Ref 1716 RVBC170911na

Date 11th September 2017

1716 Eatoughs Farm
Planning application ref. 3/2017/0765

Proposed Elevations

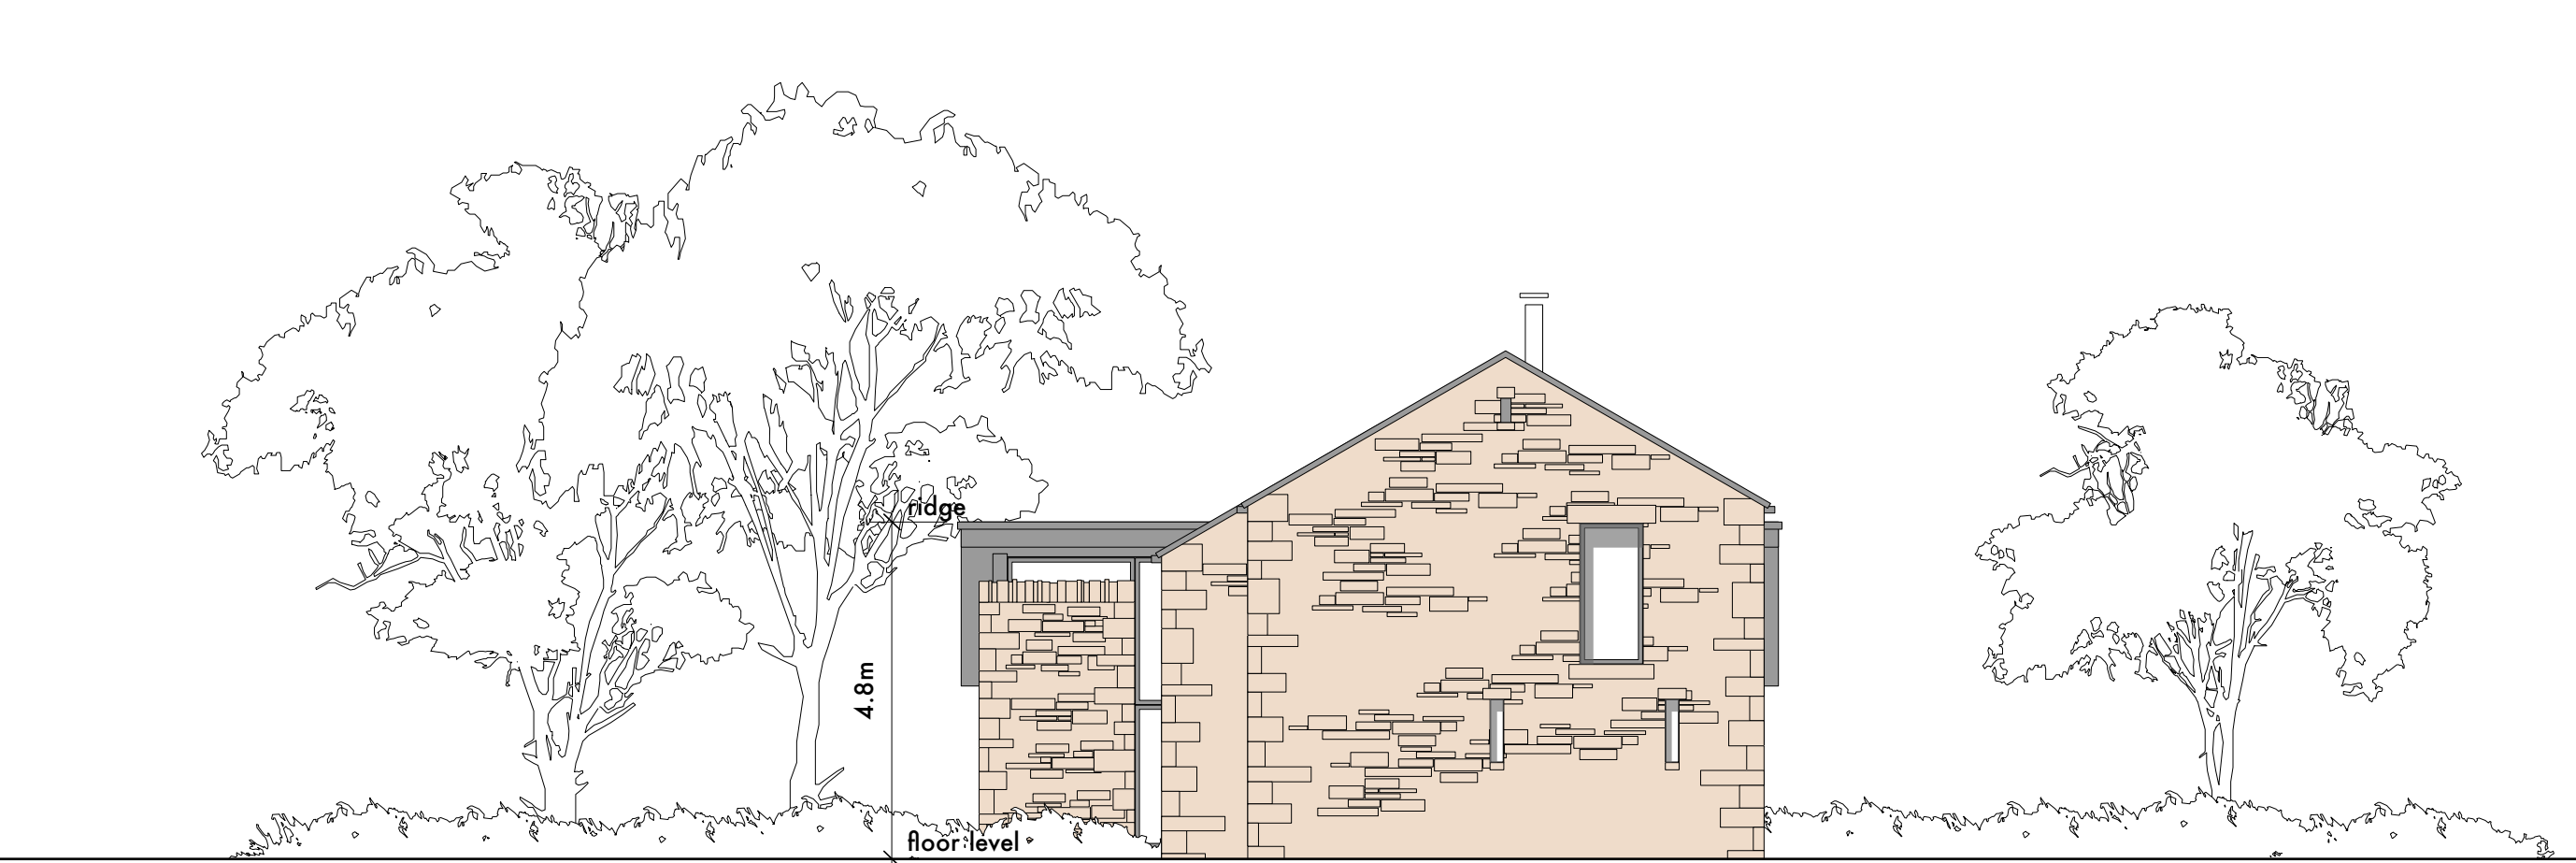
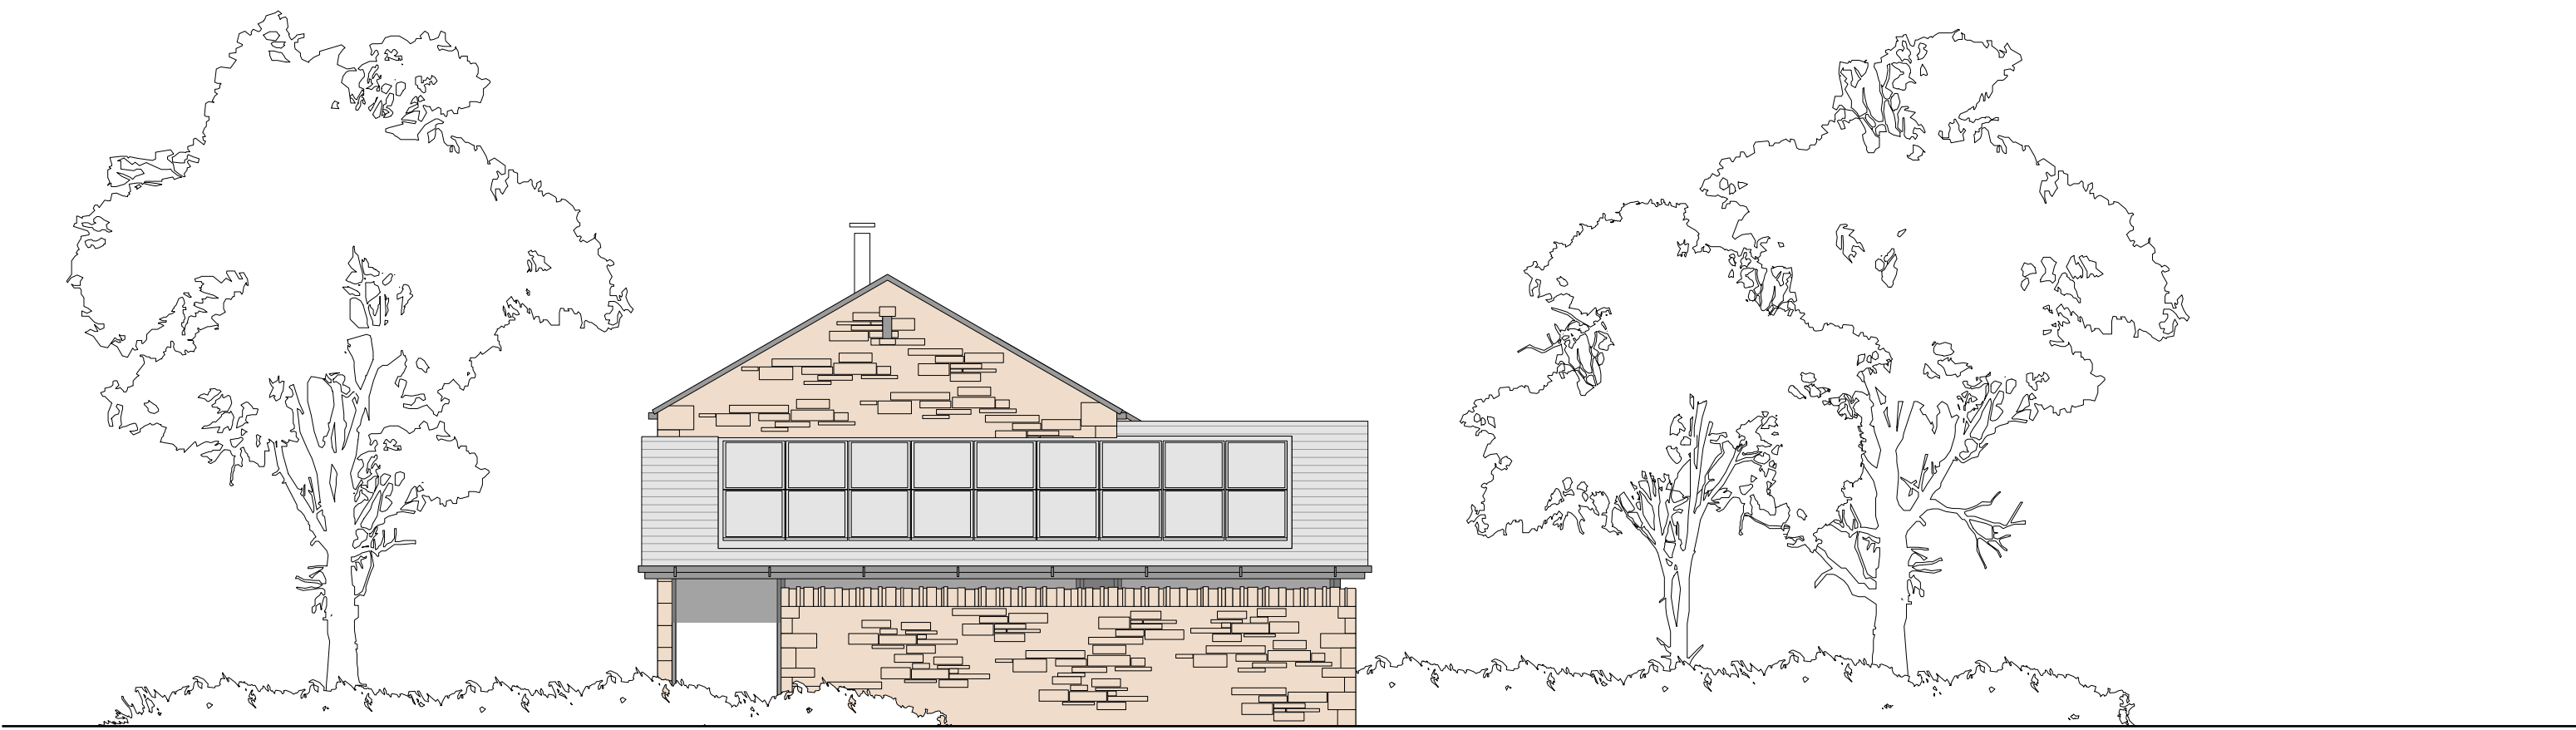
Following the submission of the application, comments have been received about the width of the window opening to the garden elevation.

However, we are also mindful of the concerns raised and the comments made and have therefore proposed reducing the width of the west facing window by approx. 1m. This would reduce the glazing to this elevation of the original barn from 48.6% (52.5m²) to 42% (45.5m²).

Please find a copy of our drawings no.1716/10c and 11c illustrating the amended arrangement and would be grateful if this could be read in conjunction with the previous planning application submission.
